**KIRKLEES METROPOLITAN COUNCIL  
INVESTMENT & REGENERATION SERVICE**

Reference No:	<b>2024/44/90239/E</b>
Site Address:	Land at, Green Acres Close, Emley, Huddersfield, HD8 9RA
Description:	Discharge of conditions 9 and 10 (ball-stop netting) of previous permission 2023/92327 for the erection of 6 dwellings, including associated parking, landscaping, open space and ball stop netting (modified proposal).
Recommending Officer:	Ellie Thornhill

**Application:** 2024/90239

**Site:** Land at, Green Acres Close, Emley, Huddersfield, HD8 9RA

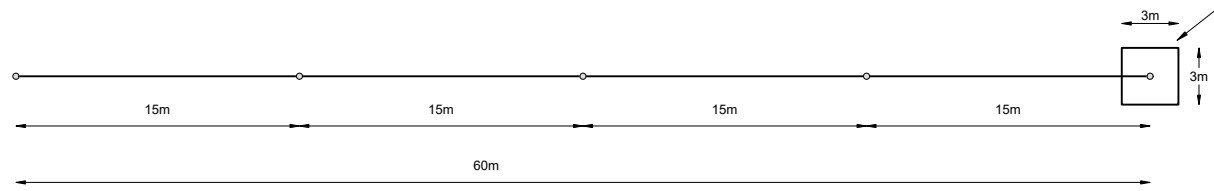
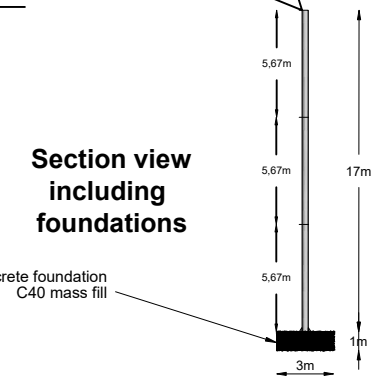
- On AJW's plan (appendix C of the report) it says in bottom right corner "this drawing is a general arrangement with dimensions shown subject to client providing final specifications for this project" But Newett refer to this plan on page 2 of their report as follows "a detailed design of the ball stop netting is provided in appendix C".

*Officer comment: This document has been amended throughout the course of the application.*

Project	Emley CC	
Description	Cricket Fencing	
Views	17m high fencing	
Scale	1:400	Sheet size
Date	05.06.24	A4
This Drawing and any designs indicated thereon are the copyright of Hi-Nets(AJW construction LTD) All rights reserved .		
Ref:DW12012422		Rev:04

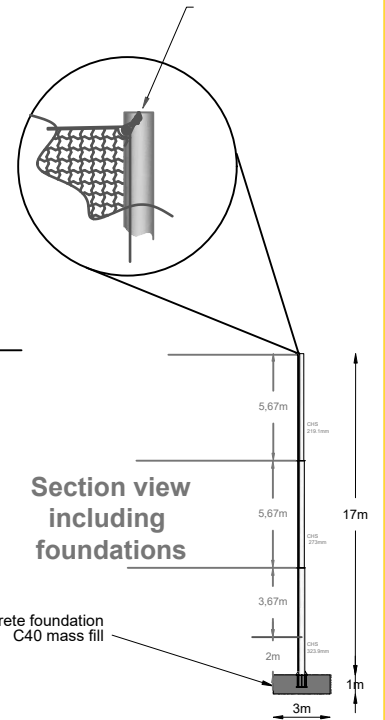
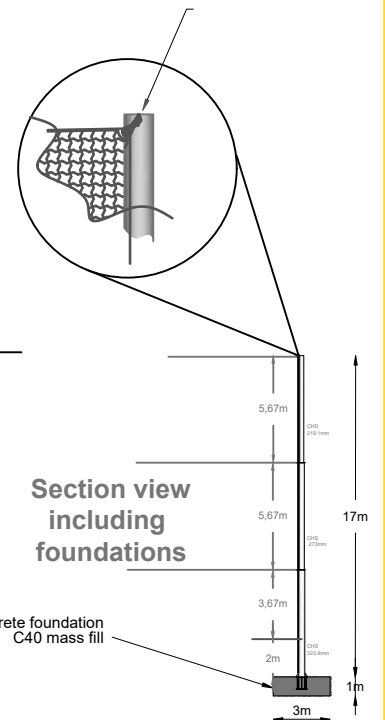
- There should also be engineers' full specification plus calculations on strength of the whole structure taking into account height and width of structure plus weather/wind conditions. Will the stanchions be strong enough to withstand winds - engineers should look at this and design diameter of stanchions, depth and width of the concrete foundations depending on the ground conditions.

- AJW's plan appears to show five narrow posts/stanchions whereas Newett Homes own section plan of the nets (in the same report) shows only three wide stanchions - this is misleading and should be clarified.

*Officer comment: Revised plans and information have been sought, along with a letter from Labosport which reviews the technical information submitted and confirms their acceptability.*

*Officer comment: Six stanchions are shown on both plans.*

Drawing Title	Ball Strike Net		
Site	Wentworth Drive, Emley		
Scale	1:200 @A2	Date	21/06/24
Drawn	MC		
Drawing No.	Z155.111	Rev.	B
Thorpe Arch Grange Walton Road Thorp Arch LS23 7BA			
01937 543599 www.newetthomes.co.uk

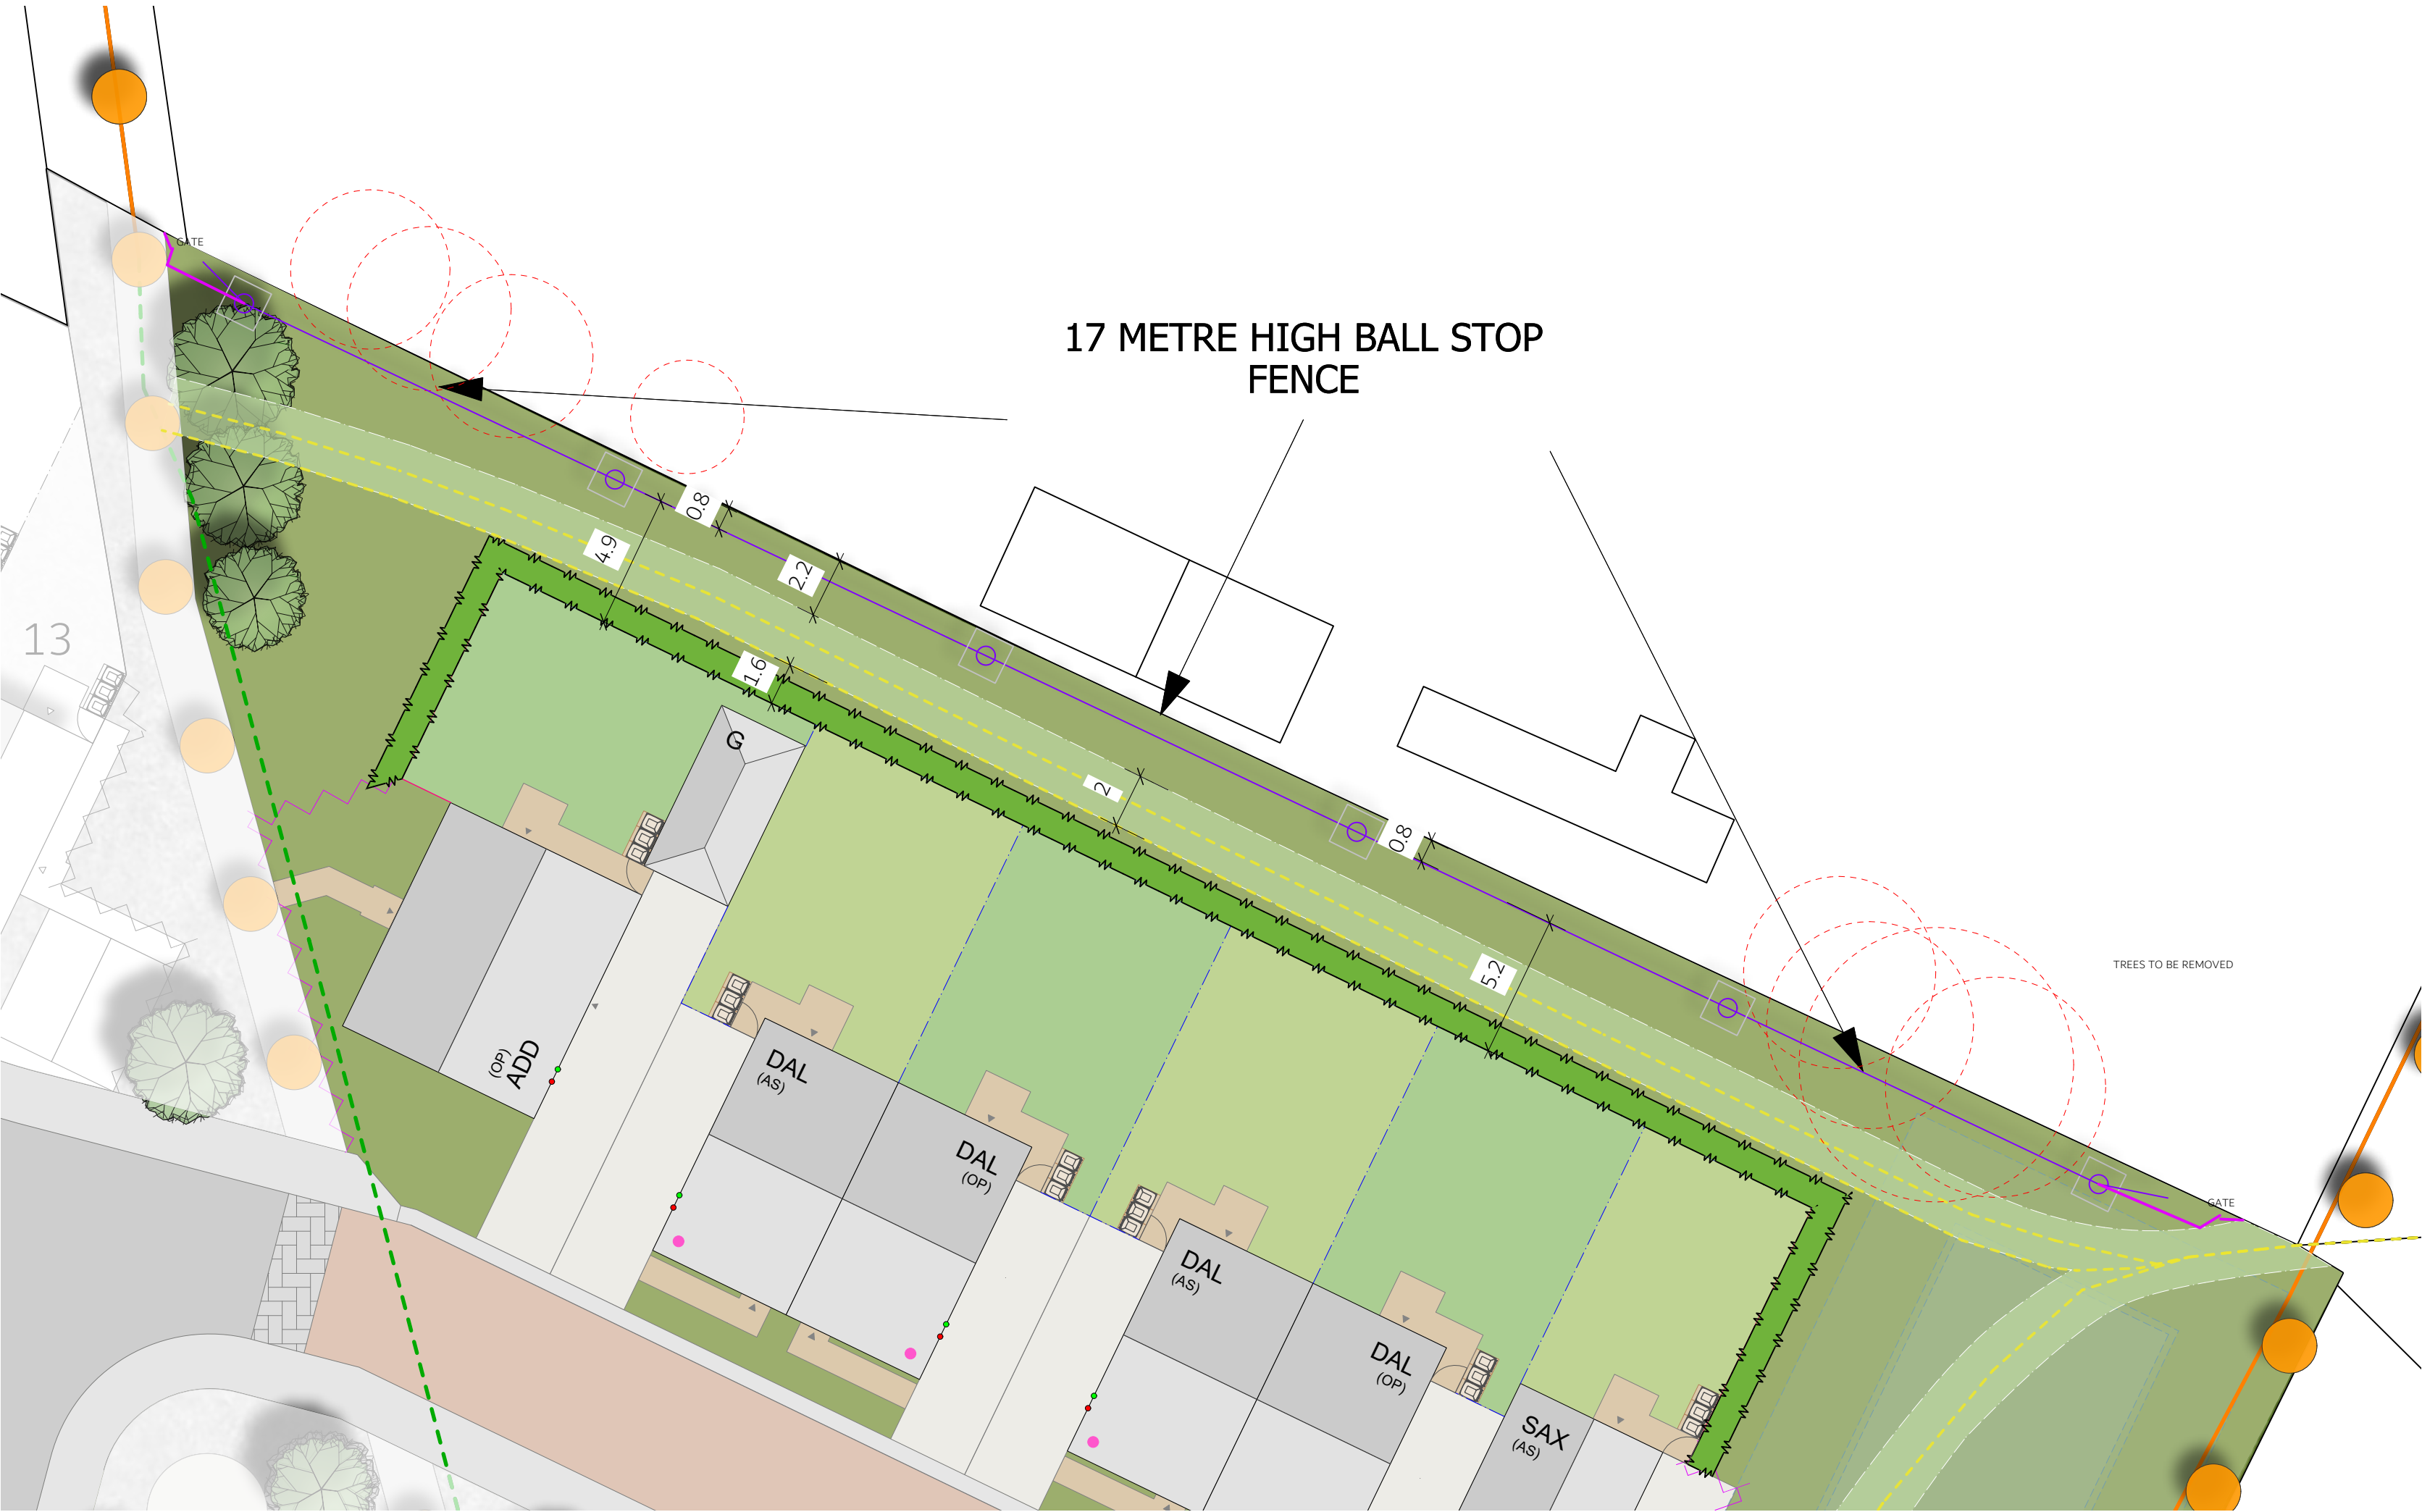
- *Drawings don't seem to reflect the presence of a 2m timber fence before the netting starts (location of pulleys also to be identified). We are also questioning the position of the fence on the drawings versus the reality of the existing site boundary, the PROW runs across the boundary.*

**Officer comments:** The pink line on the plan Z155.111 rev B shows the location of the fencing. The fence would then run underneath the ball stopping net, as shown on DW12012422 rev 04 up until the end stanchions.
